Our Ref: BTC00
Your Ref:
Date: 12th February 2021

**DEADLINE 3 – APPLICATION BY HIGHWAYS ENGLAND FOR A DCO FOR THE A1 IN
NORTHUMBERLAND – MORPETH – ELLINGHAM
COMMENTS ON RESPONSES SUBMITTED FOR DEADLINE 2**

Drawing Number: HE551459-WSP-ELS-A2E-DR-LE-1817
 Revision: P04
 PW Stage Code: 0

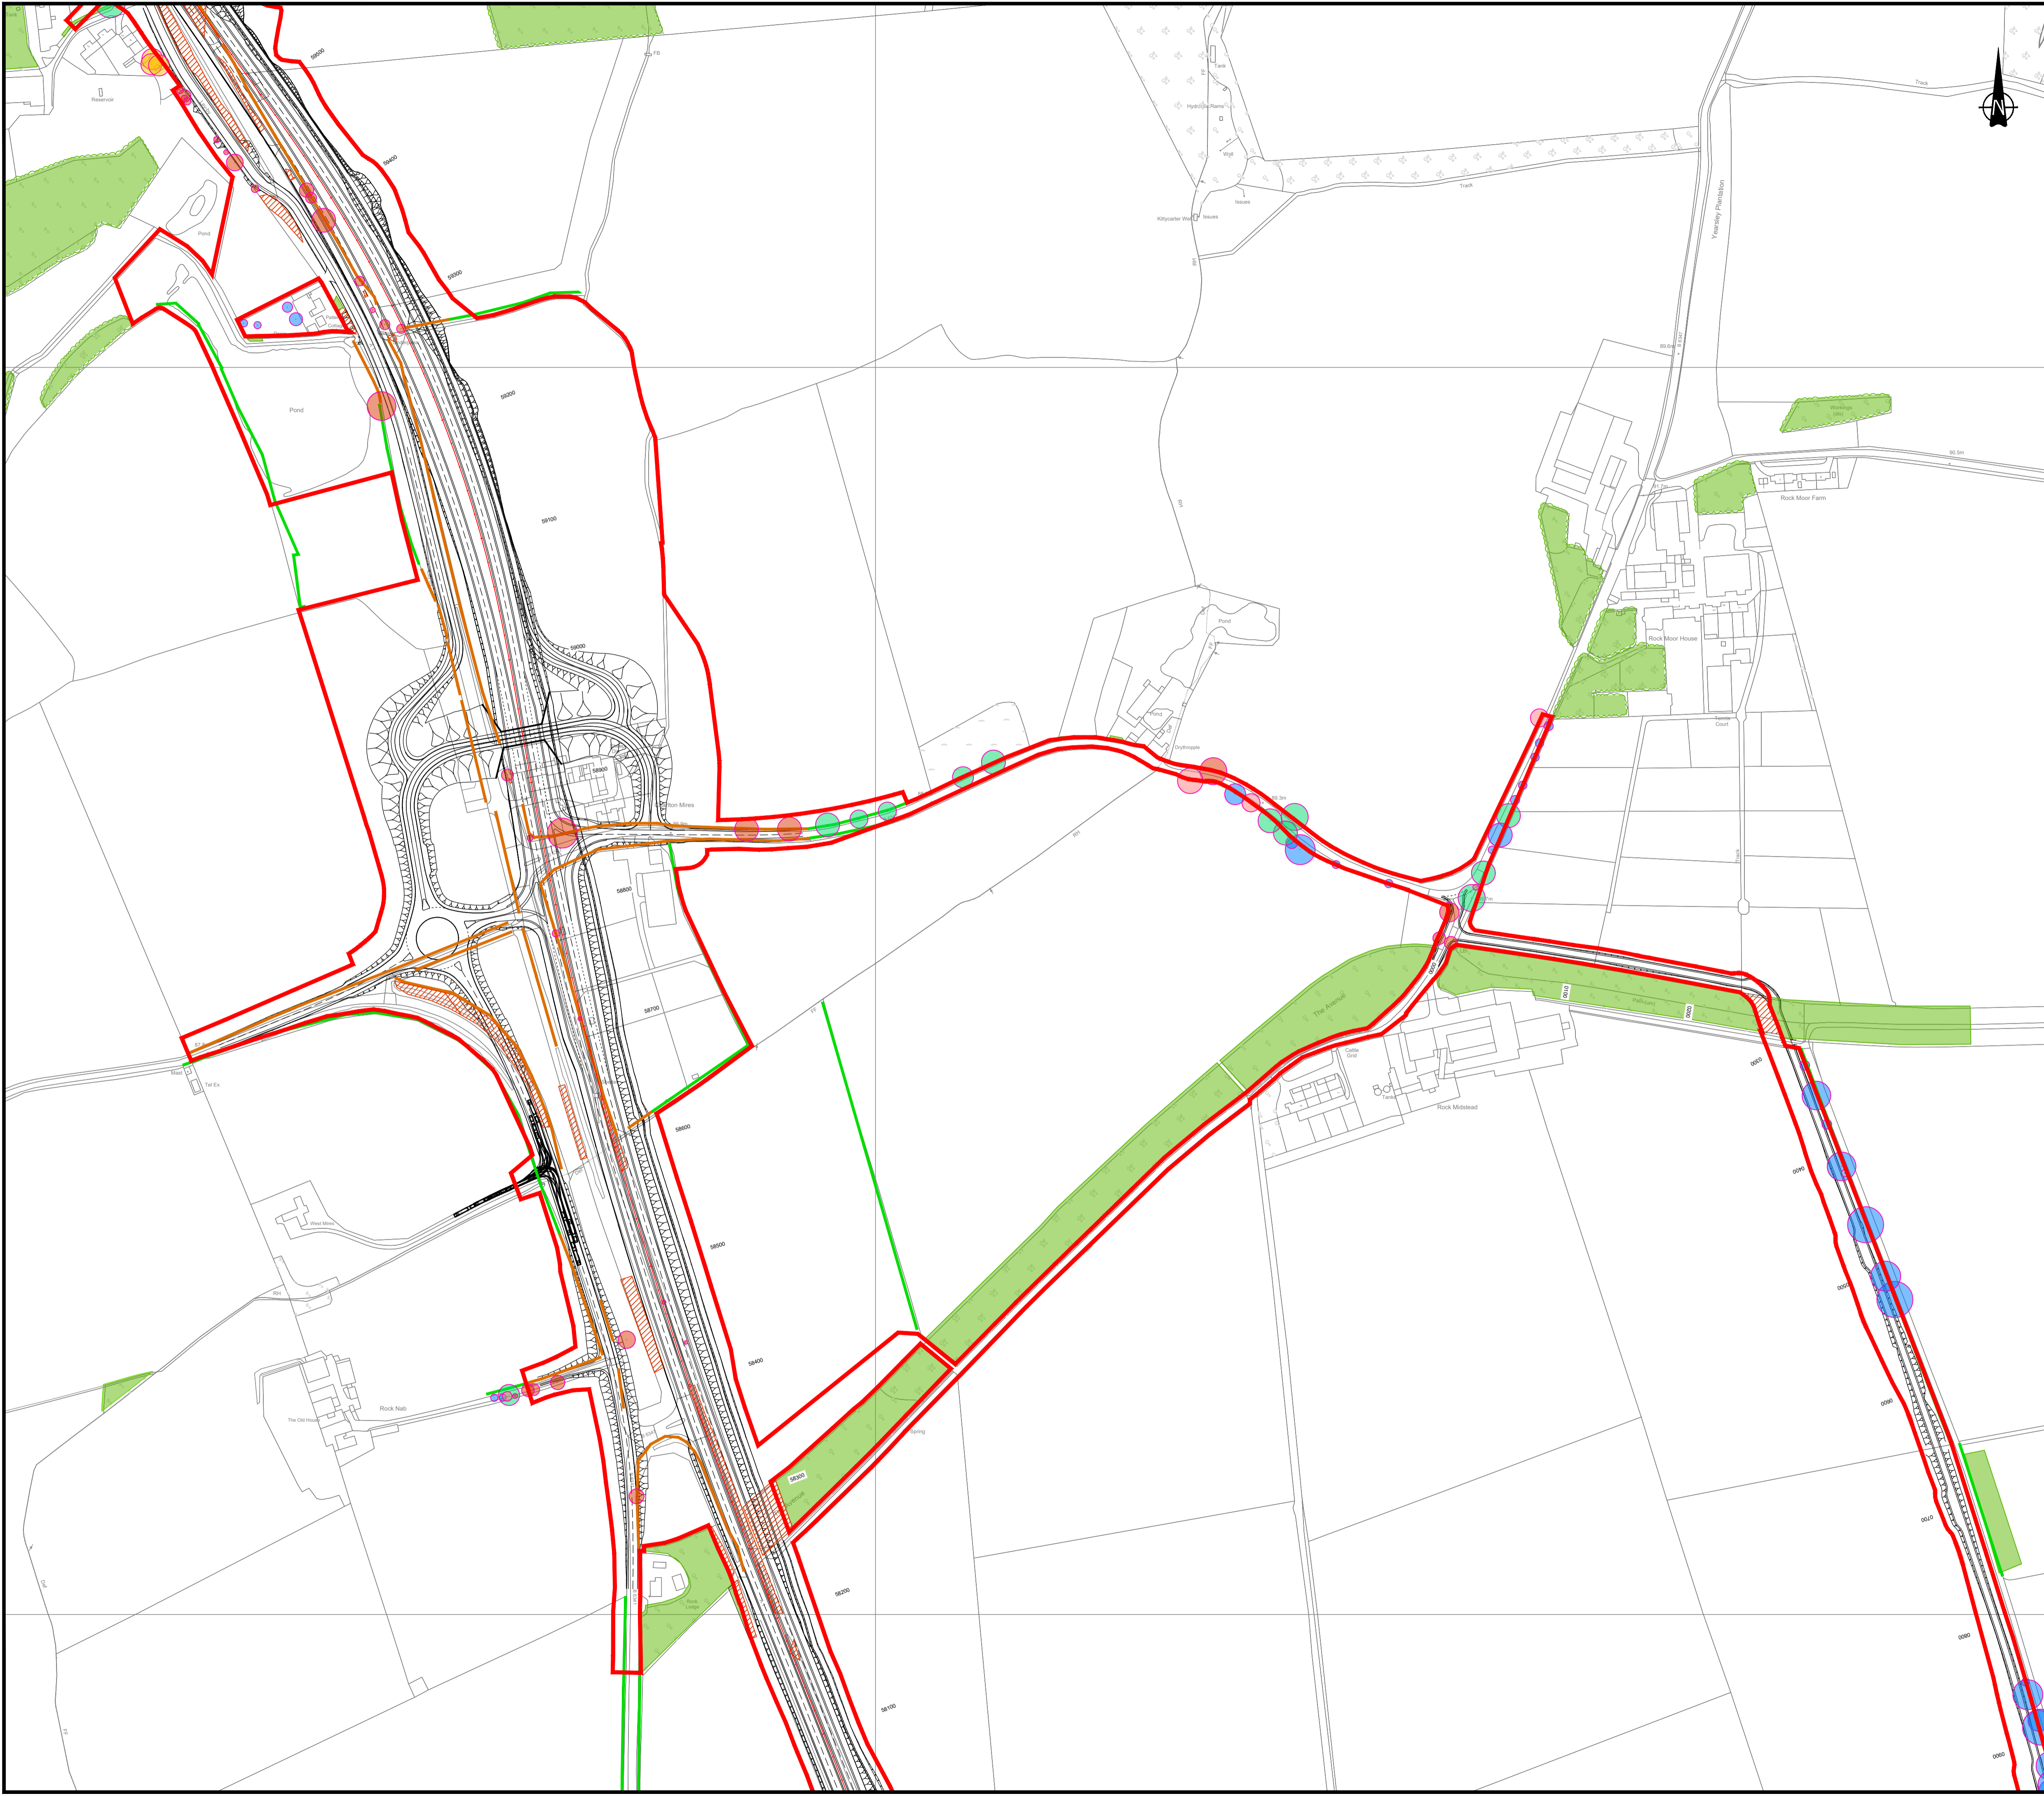
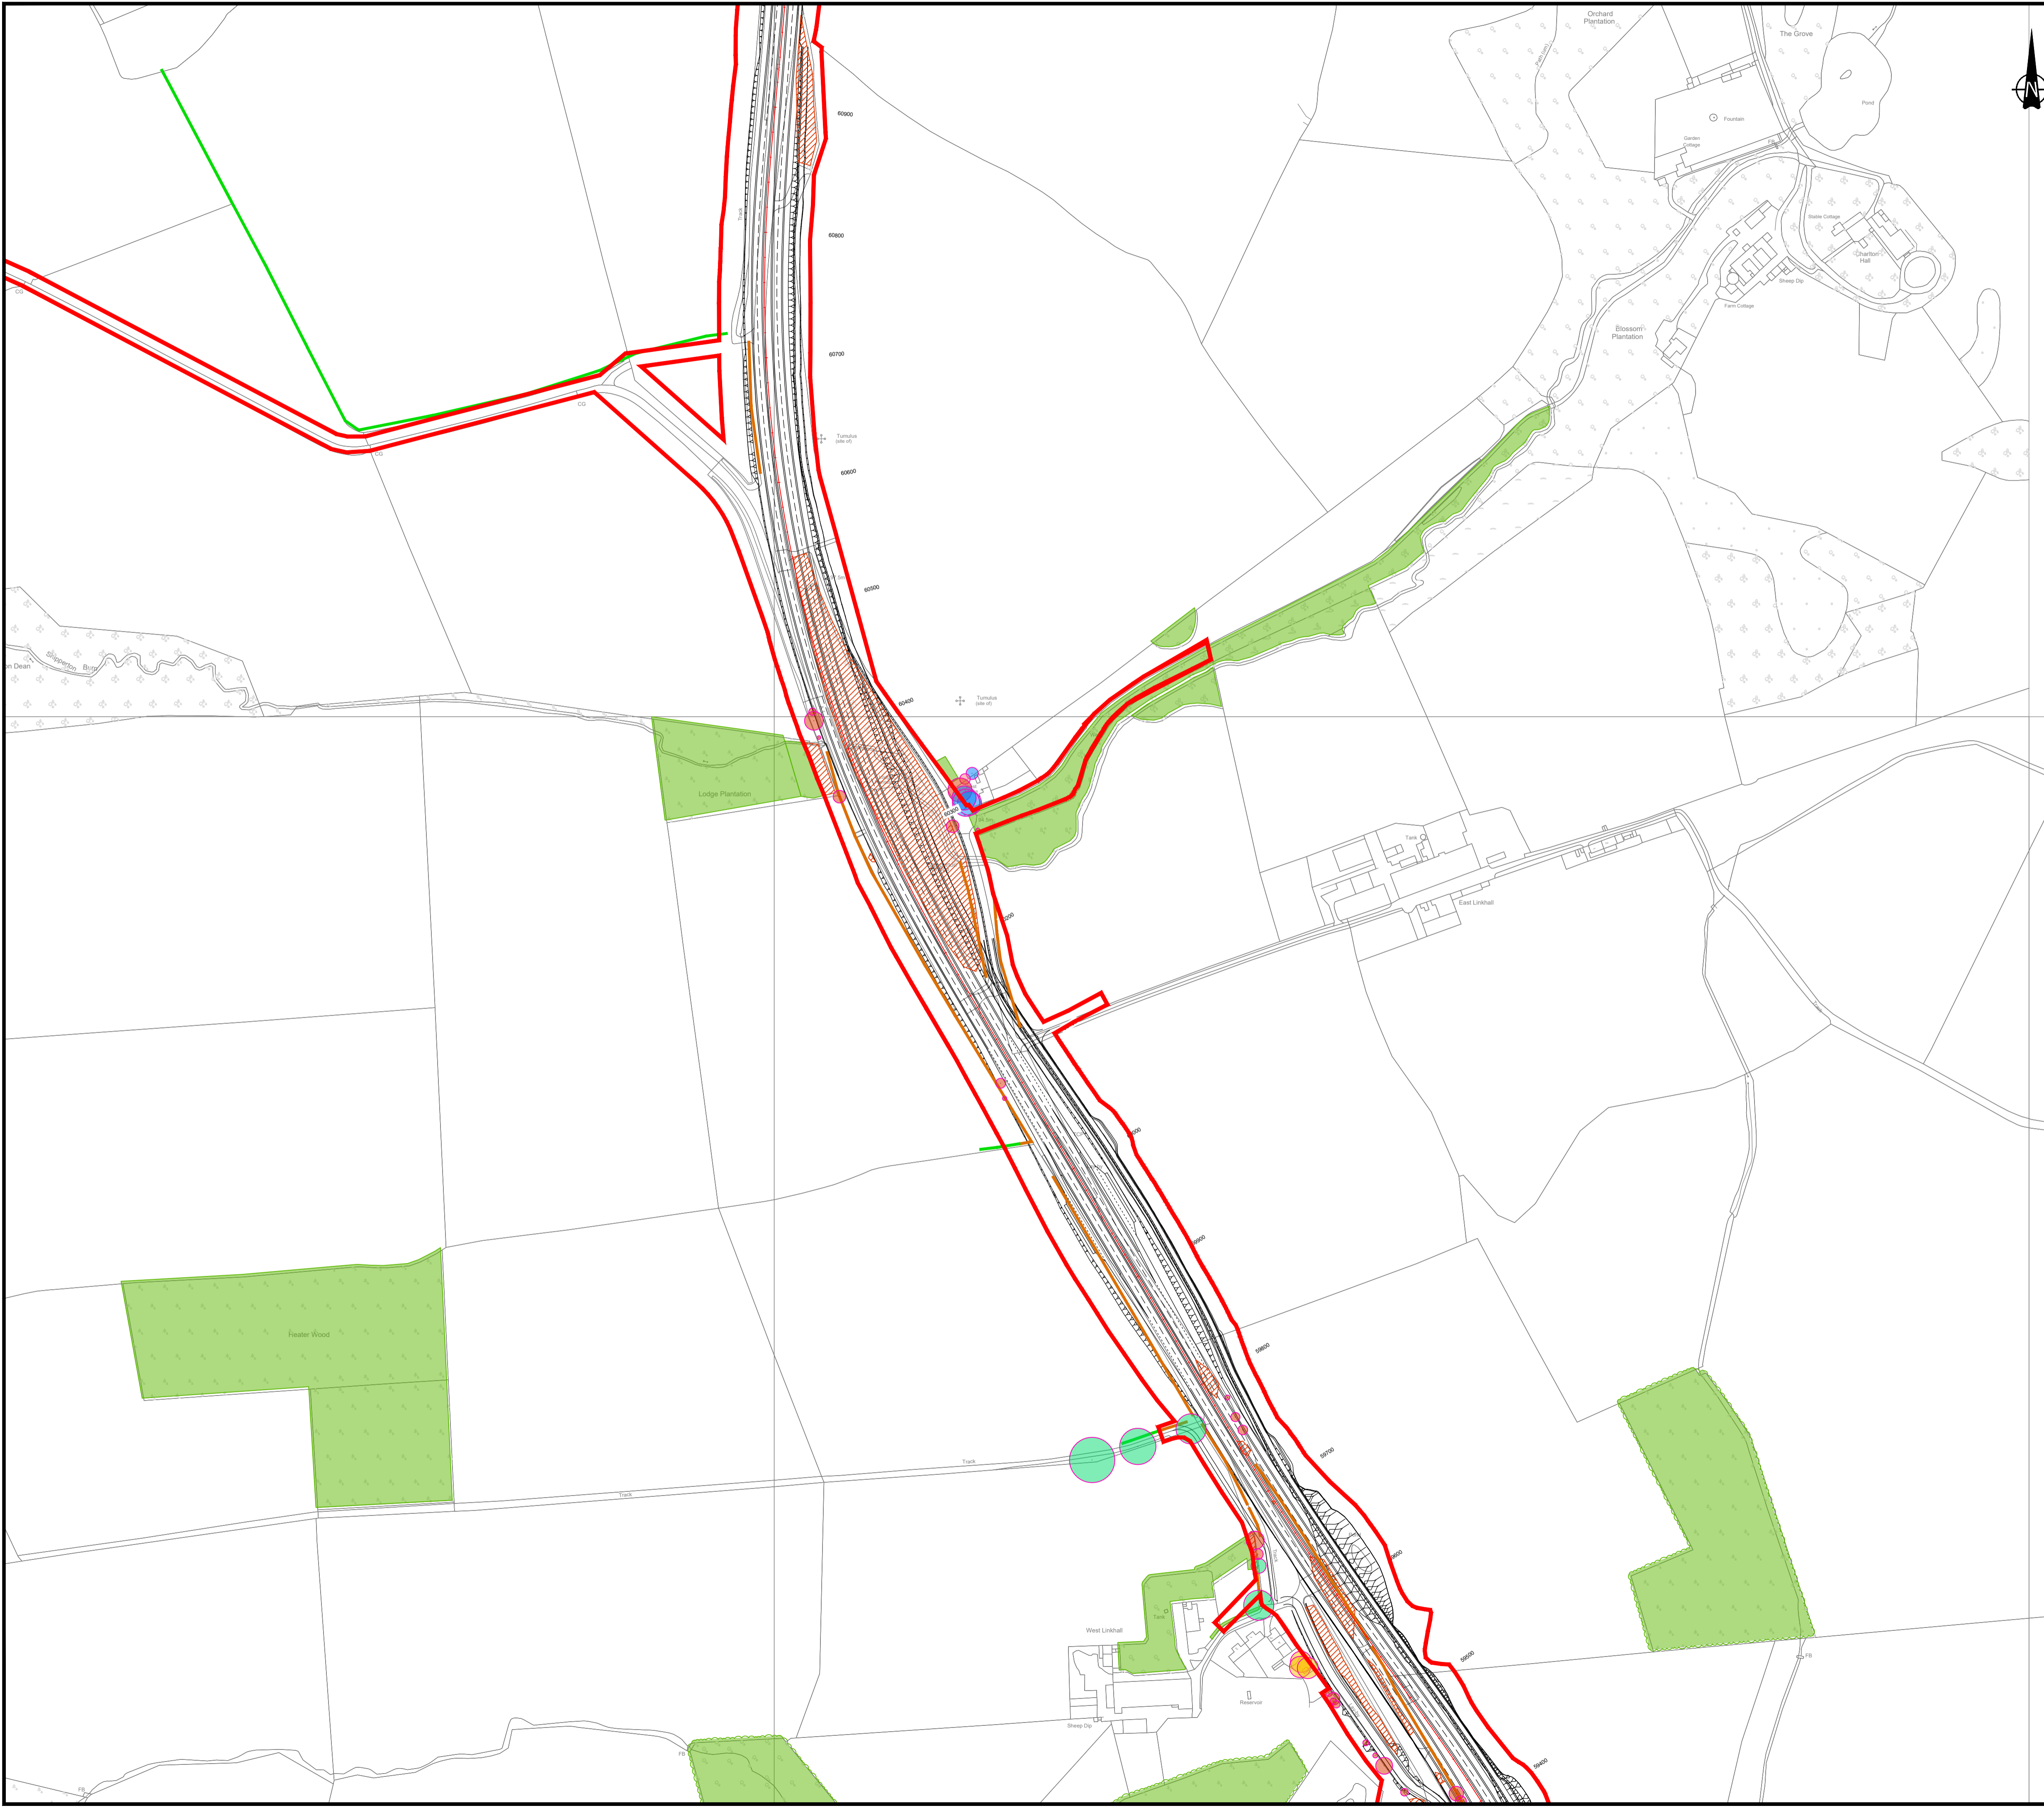
1. Vegetation Clearance –we note submission of Document TR010059 – 001182 6.6 ED Part B Figure 7.11. The document states that vegetation in front of West Linkhall Farm and West Lodge at Charlton Hall is to be removed. We have had verbal confirmation that this is not the case and that whilst some maybe removed, not all of it will be. We are concerned that the DCO is assuming the full removal and we would contest that this is not necessary following conversations with HE and their representatives.
